**Consultation Response from KC,  
Lead Local Flood Authority**

**2023/91116 Land off, Primrose Lane, Hightown, Liversedge, WF15**

**Erection of 77 dwellings, with access from Darley Road and associated works**

**Date Responded: 10/07/2024.**

DRAINAGE STRATEGY

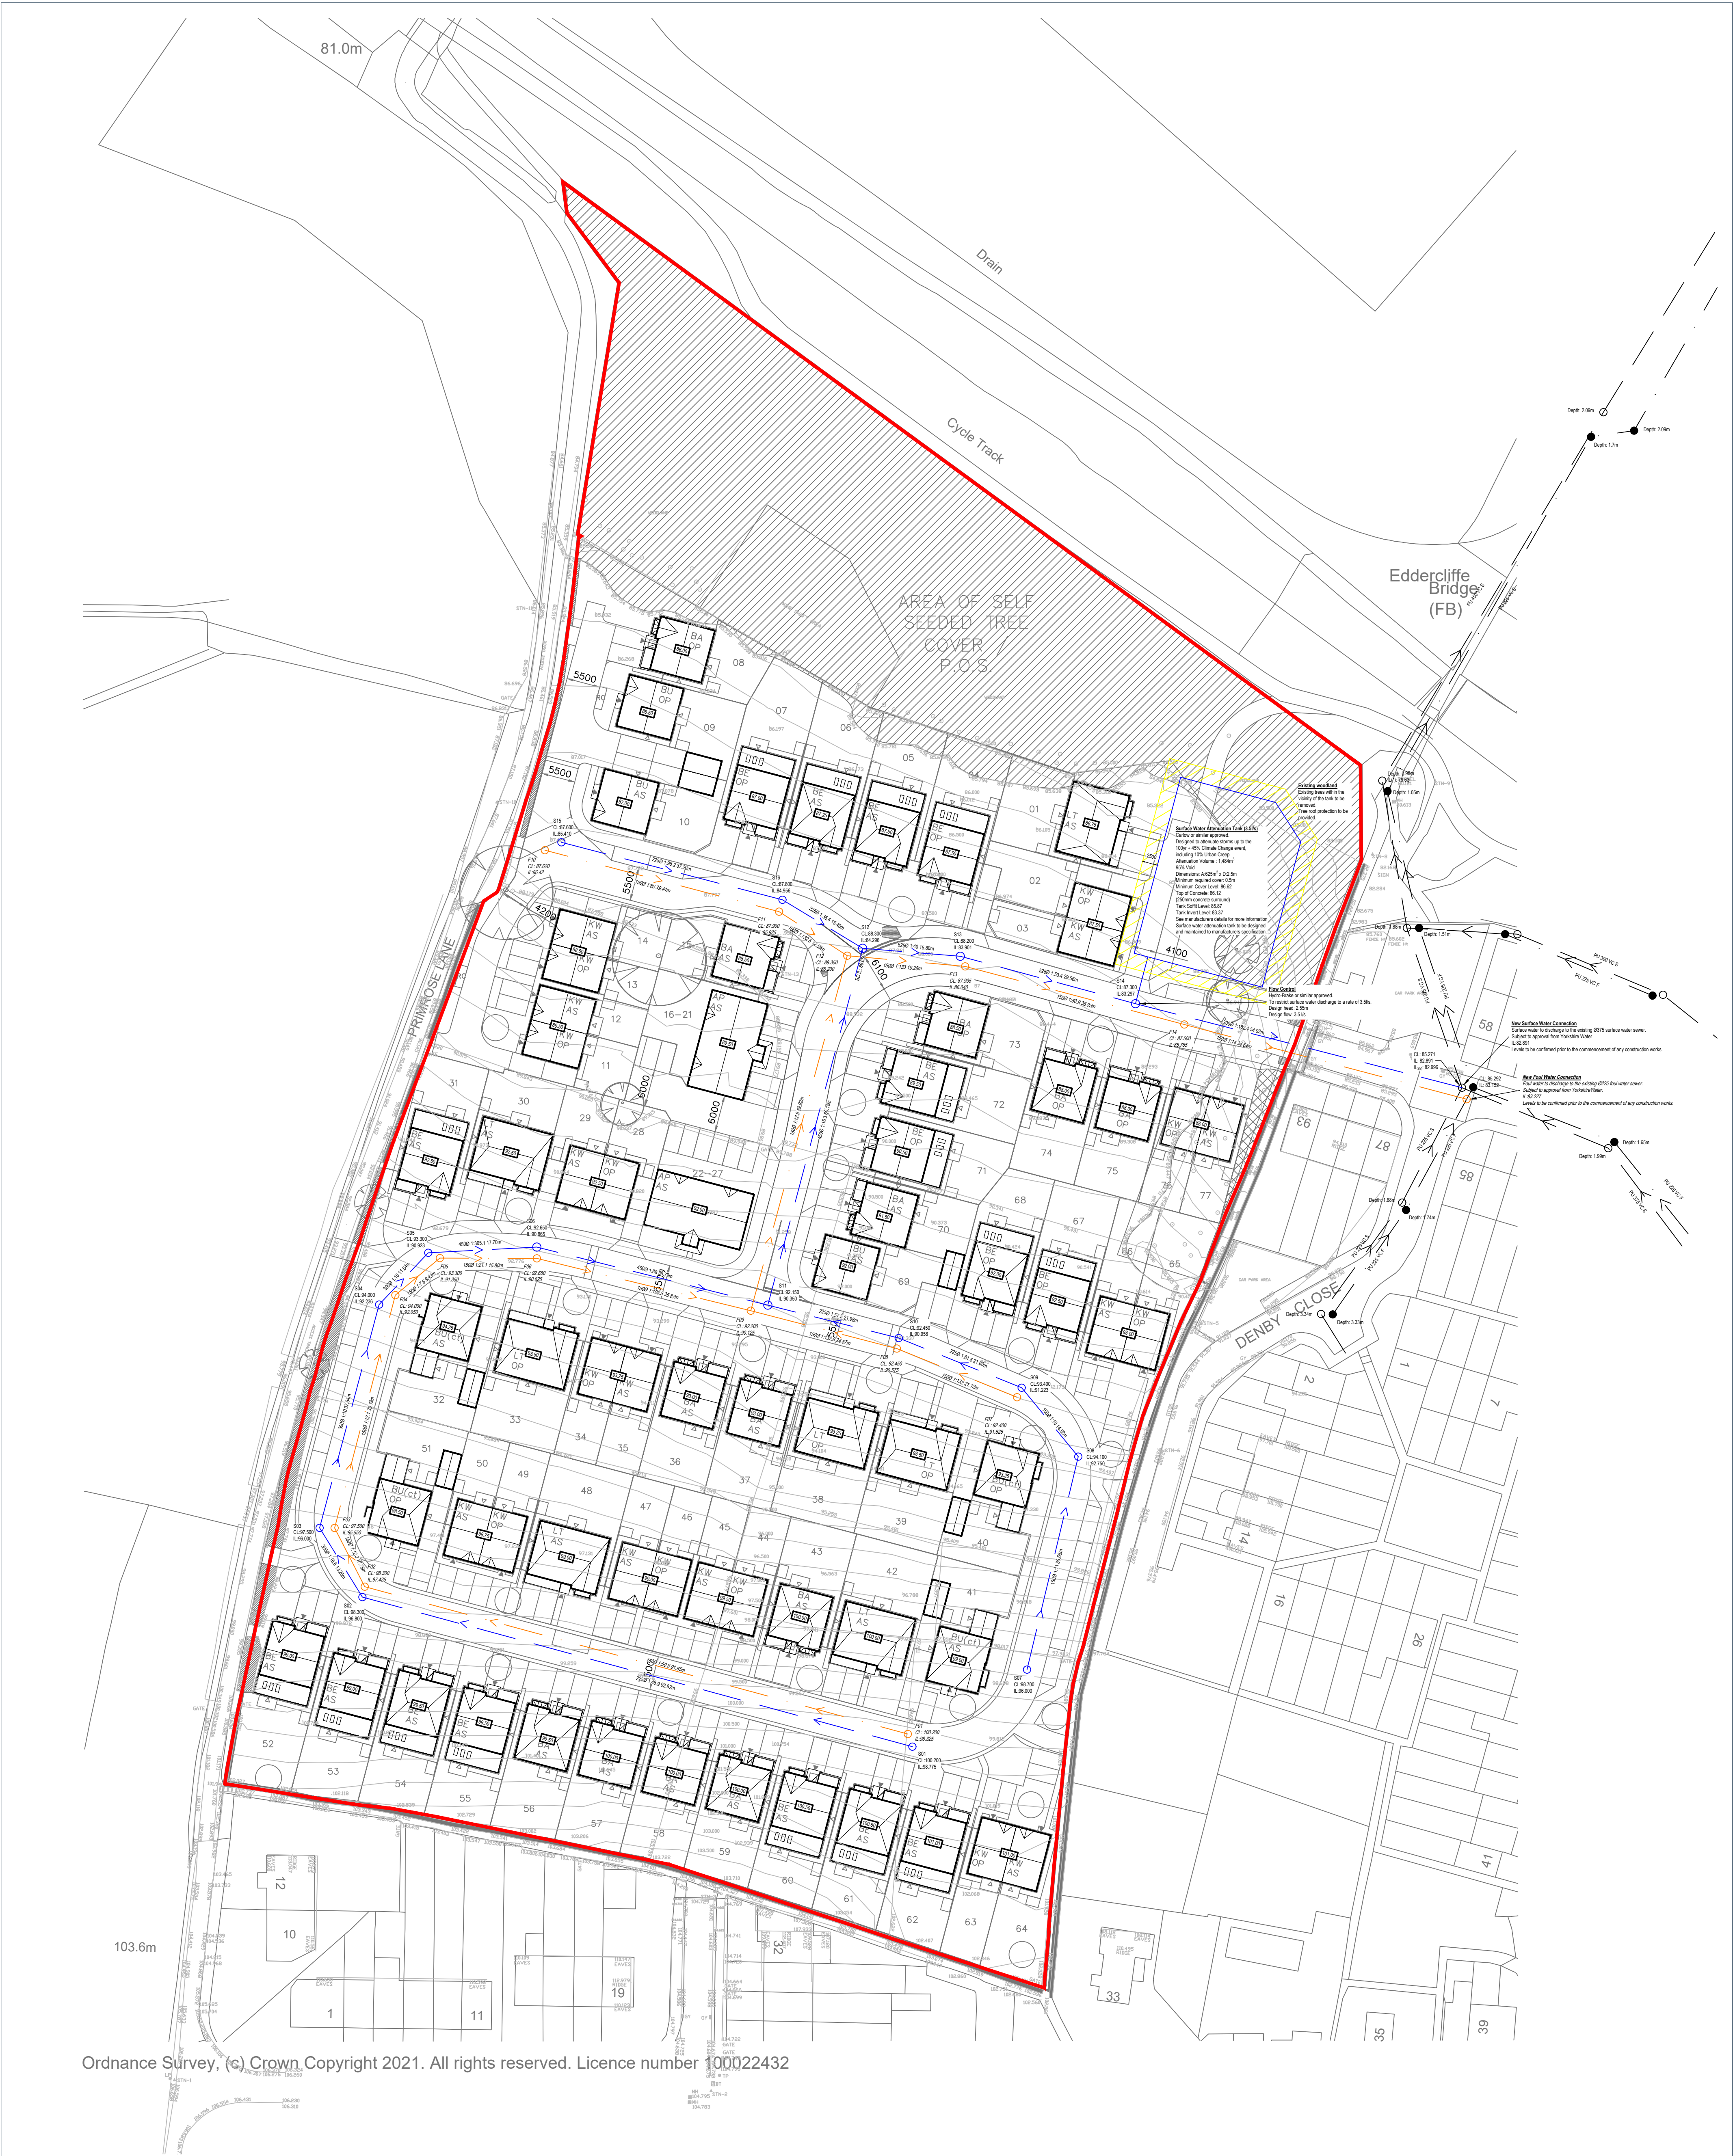
Further, the LLFA confirms the proposal to use a Carlow type tank with an attenuated flow storage volume of 1,484m<sup>3</sup> as indicated on the Drainage Strategy drawing.

However, it is noted that in the calculations, there is flooding indicated at Node 15 and the Tank Inlet for the 1 in 100 year (+CC) rainfall event. These volumes should be minimised as far as practicable.

Revised calculations/drawings indicating the changes noted above should be submitted to the LPA at the discharge of conditions stage.
